14 December 2020

Our Ref: R/2019/22/A
File No: 2020/510738
Your Ref: SSD-10382

90-102 Regent Street, Redfern – Student Accommodation (SSD-10382)

Thank you for your correspondence dated 16 November 2020 requesting for the City of Sydney Council (“the City”) to comment of the state significant development application for student accommodation at 90-102 Regent Street, Redfern.

1 DA GROUND (L1) FLOOR PLAN  
1:200

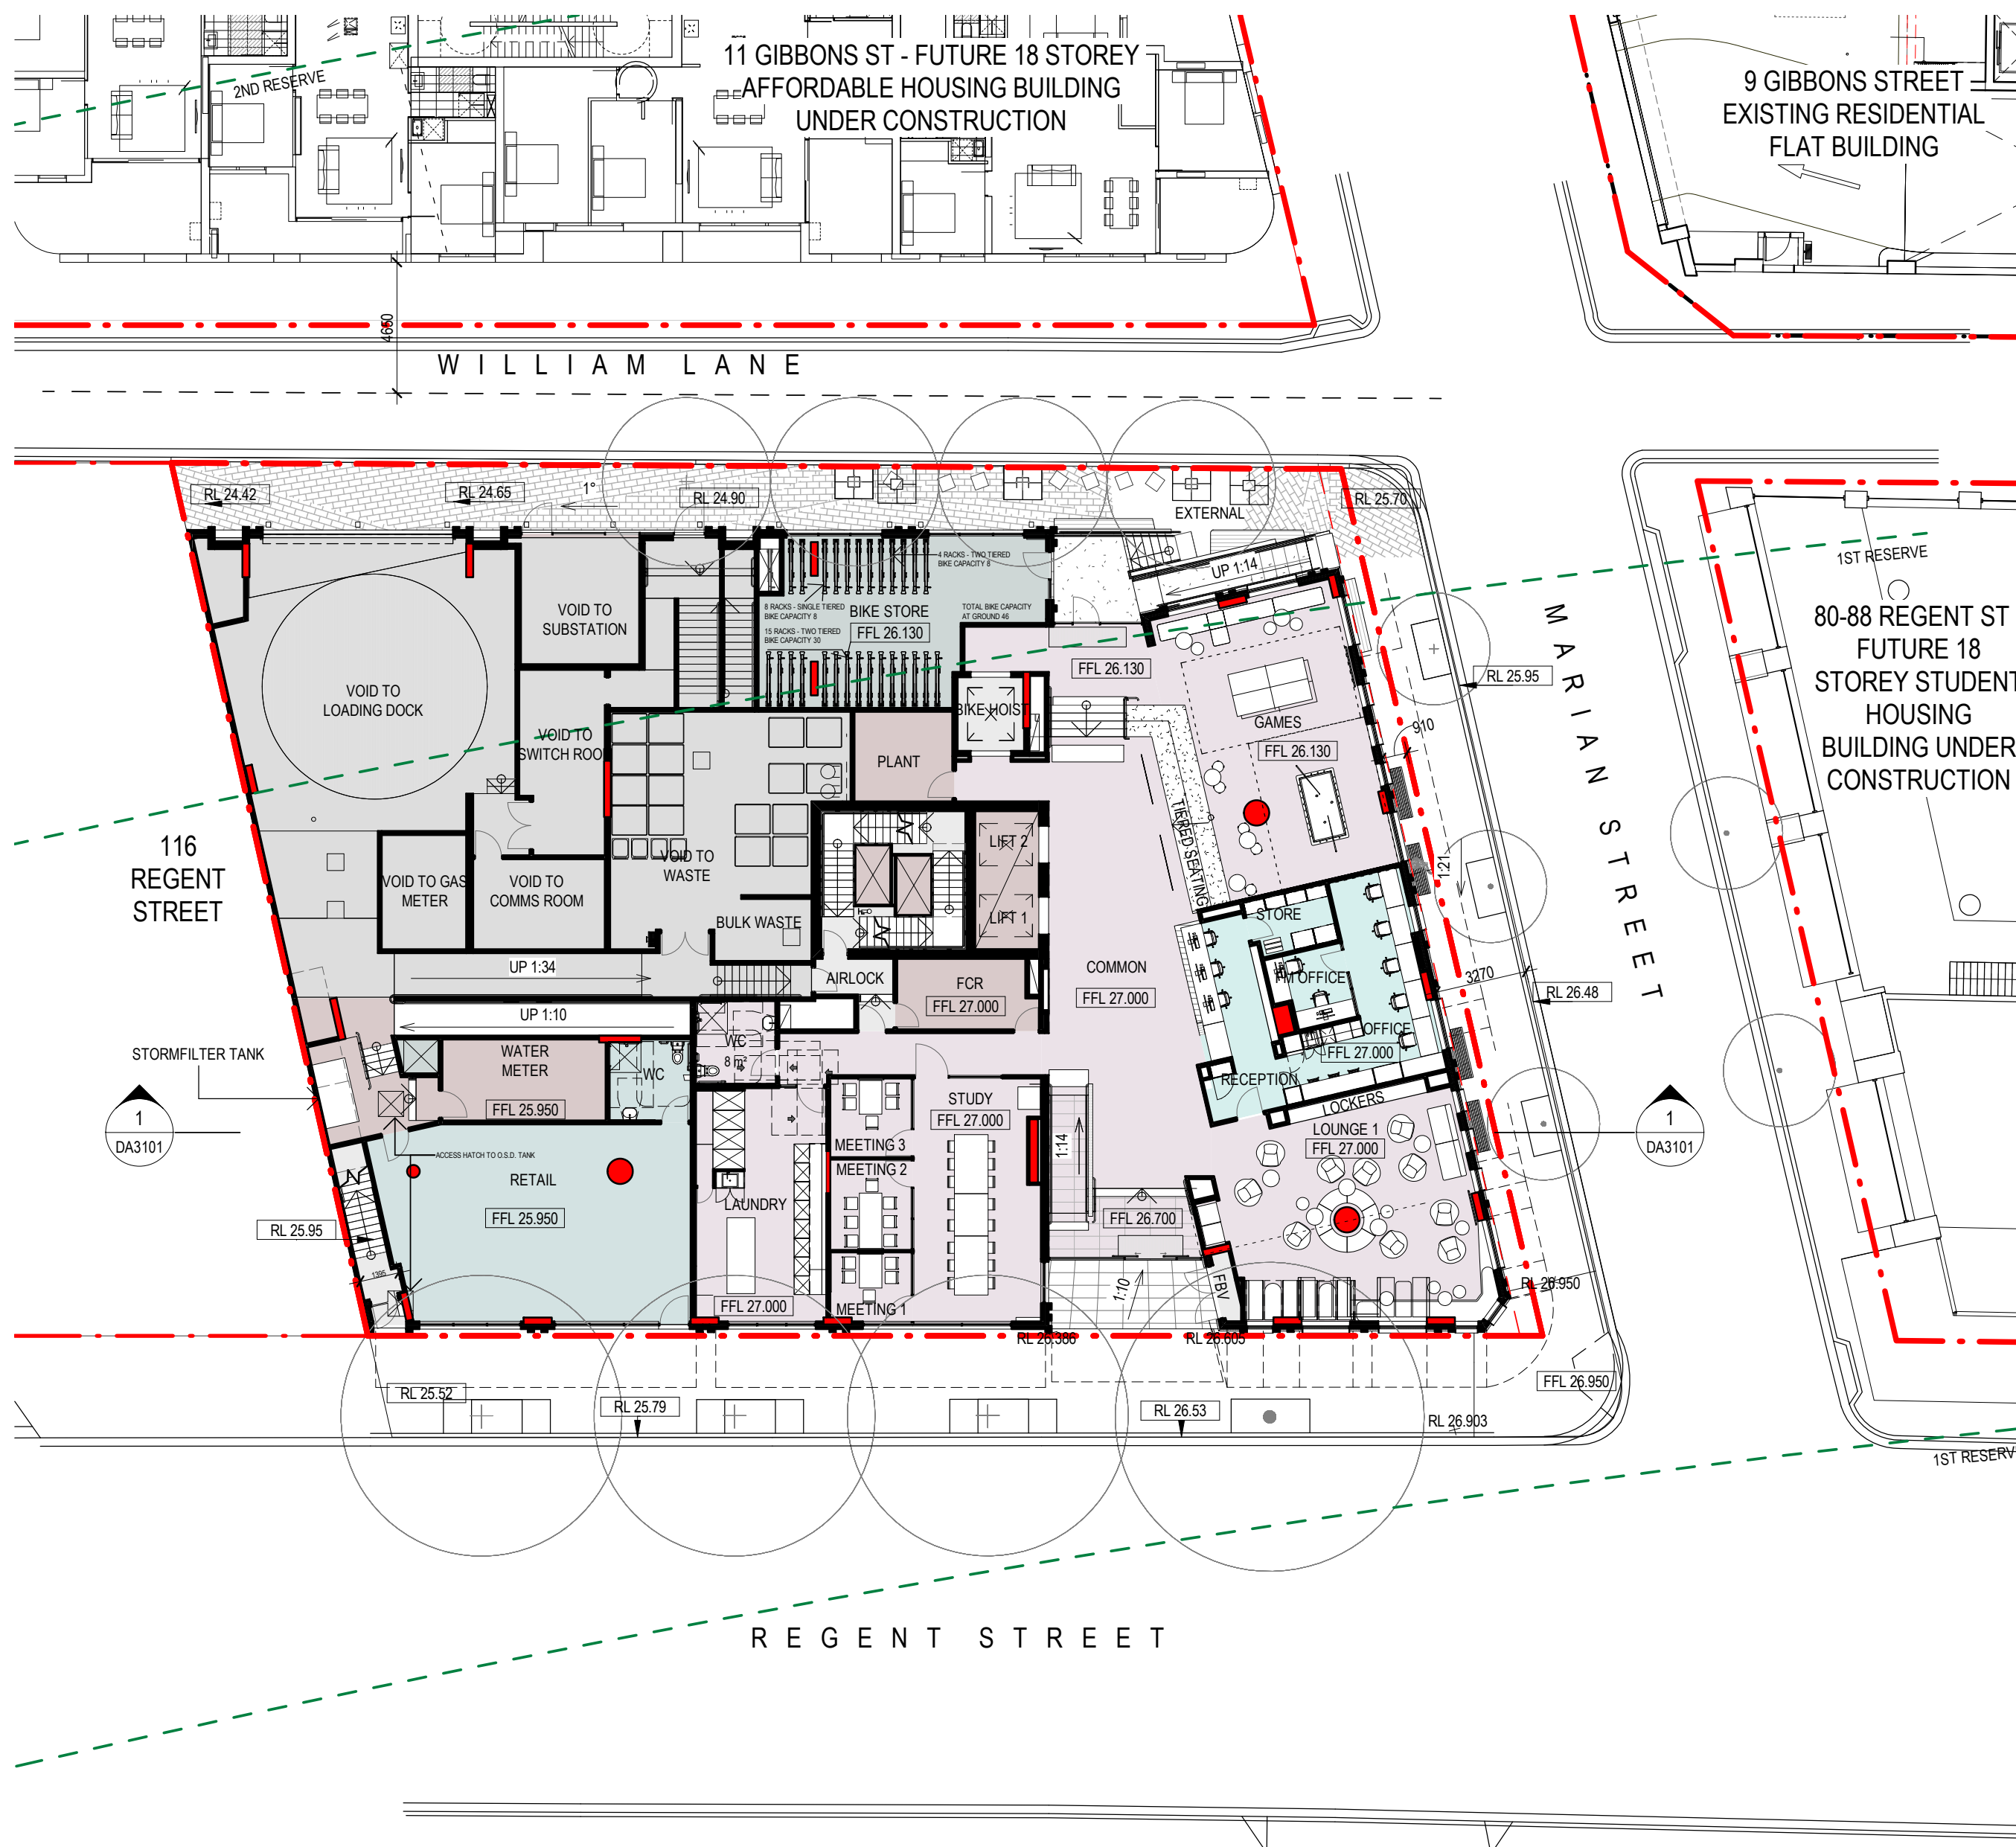
The proposal matches the ground level street setback to Marian Street provided by 11 Gibbons Street of 0.8m and presents a numerical departure to the 1.5m setback requirement. The ground level architectural plan shows benches within the setback. These are to be removed as the setback is for footpath widening not for street furniture.

There are trees planted within the setback long William Lane to ameliorate wind impacts. These trees are to be located 0.8m setback from the boundary in order to provide pedestrian amenity. This is also consistent with the sites to the north of Marian Street, which have delivered 0.8m setback for footpath widening along William Lane.

2 LEVEL 2 PLAN  
1:200

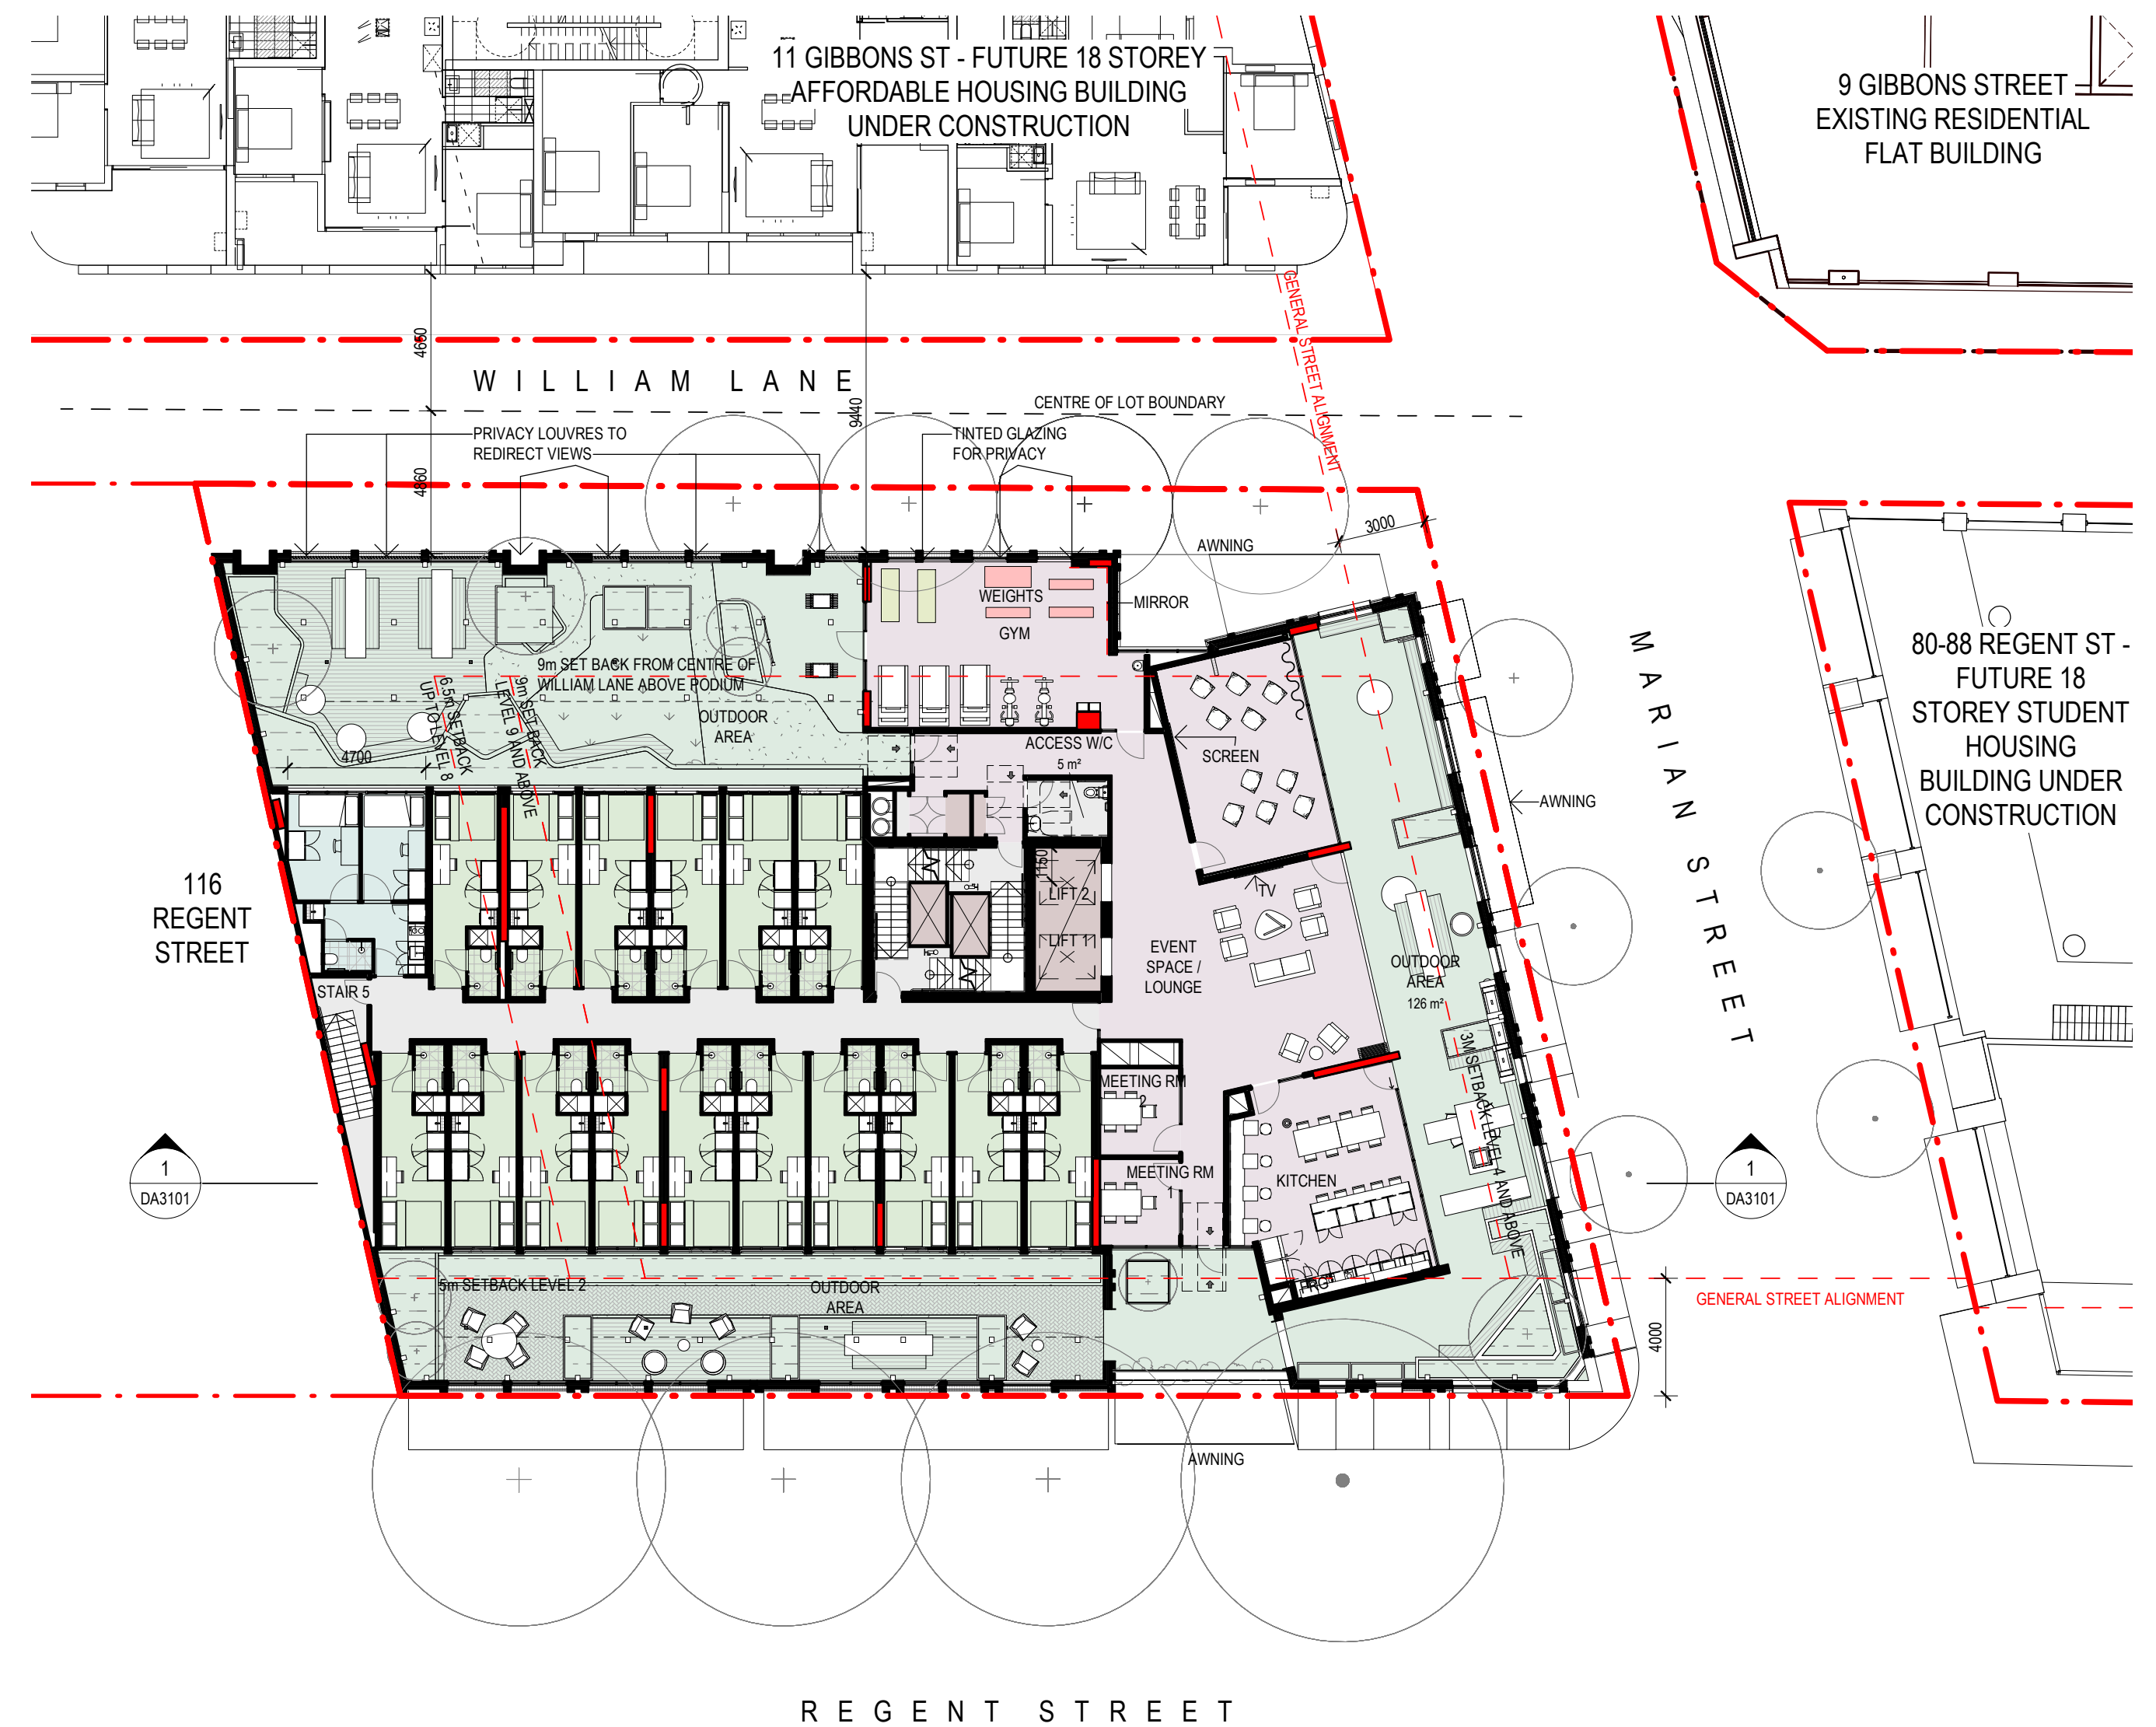
The podium is the location of the Level 2 communal open terraces. A reliance on landscaping to completely mitigate wind is not supported as the trees may fail and die. It is unclear if the proposal relies on full height balustrades and screens to mitigate wind effects on the Level 2 common open space. It is recommended that the façade design be amended to limit wind effects and downwash to the common open space, noting this is the only open area for the students. Further wind tunnel testing should be carried out that includes the full design to meet the relevant safety criteria.

Landscaping on the Level 2 communal area is in undersized raised planters and pots and areas of astro turf. Synthetic astro turf are not supported. Due to the artificial nature, a plastic turf surface finish does not contribute any biophilic and biodiversity outcomes and is likely to end up in landfill in the future. In warmer summer months the surface finish traps heat and is a hot surface.

Proposed new trees that are in raised planters and free-standing pots are too small and shallow to support the healthy growth of trees, let alone in high wind environment. The landscape proposal does not comply with minimum soil depths and soil volumes required by the Sydney Landscape Code. Elsewhere, perimeter planters are 600mm wide and 450mm depth. The success of landscape on slab requires great design, coordinated services, soil depth and soil volume, drainage, watering systems and ongoing maintenance. These details should be provided.
